From: Laura Gibbons
Sent: 27 August 2019 13:38
To: Planning.Responses <Planning.Responses@arun.gov.uk>
Cc: Amber Willard <Amber.Willard@arun.gov.uk>
Subject: RE: Planning Consultation on: AL/62/19/PL

Engineers Comments Regarding Surface Water Drainage

APPLICATION NO: AL/62/19/PL

Site Address: Land Rear of Sundown Littleheath Road Aldingbourne BN18 0SR

Image of initial test taken on site within a 300 x 300 test hole at 800mm depth.

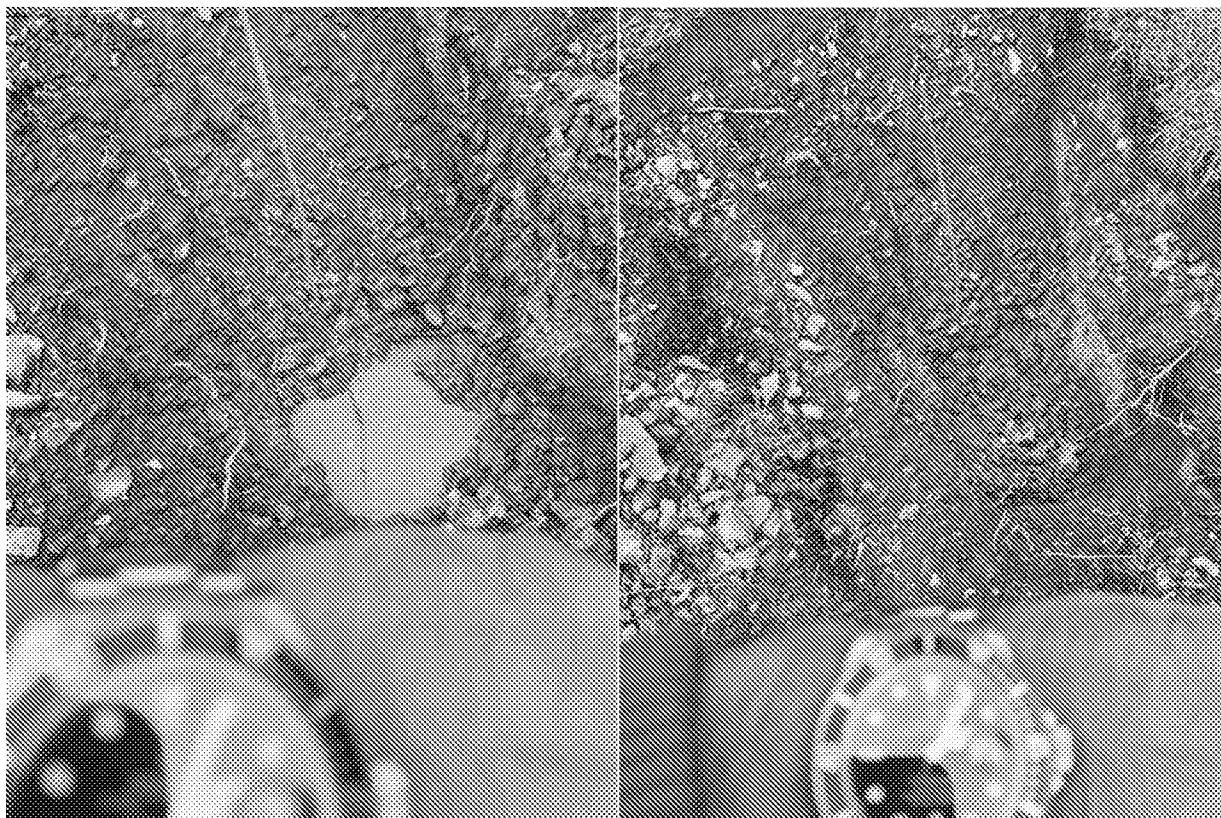
The application is within the Lidsey Catchment. Some infiltration testing has been completed, but this was not completed to BRE365 and the date of this testing is unknown. Full BRE365 compliant winter infiltration testing and winter groundwater monitoring must be completed. If you are minded to approve this application please apply the following condition:

"Development shall not commence, other than works of site survey and investigation, until full details of the proposed surface water drainage scheme have been submitted to and approved in writing by the Local Planning Authority. The design should follow the hierarchy of preference for different types of surface water drainage disposal systems as set out in Approved Document H of the Building Regulations, and the recommendations of the SuDS Manual produced by CIRIA. Winter groundwater monitoring to establish highest annual ground water levels and winter Percolation testing to BRE 365, or similar approved, will be required to support the design of any Infiltration drainage. No building / No part of the extended building shall be occupied until the complete surface water drainage system serving the property has been implemented in accordance with the agreed details and the details so agreed shall be maintained in good working order in perpetuity."

"Infiltration rates for soakage structures are to be based on percolation tests undertaken in the winter period and at the location and depth of the proposed structures. The percolation tests must be carried out in accordance with BRE365, CIRIA R156 or a similar approved method and cater for the 1 in 10 year storm between the invert of the entry pipe to the soakaway, and the base of the structure. It must also have provision to ensure that there is capacity in the system to contain below ground level the 1 in 100 year event plus 40% on stored volumes, as an allowance for climate change. Adequate freeboard must be provided between the base of the soakaway structure and the highest recorded annual groundwater level identified in that location. Any SuDS or soakaway design must include adequate groundwater monitoring data to determine the highest winter groundwater table in support of the design. The applicant is advised to discuss the extent of groundwater monitoring with the Council's Engineers.
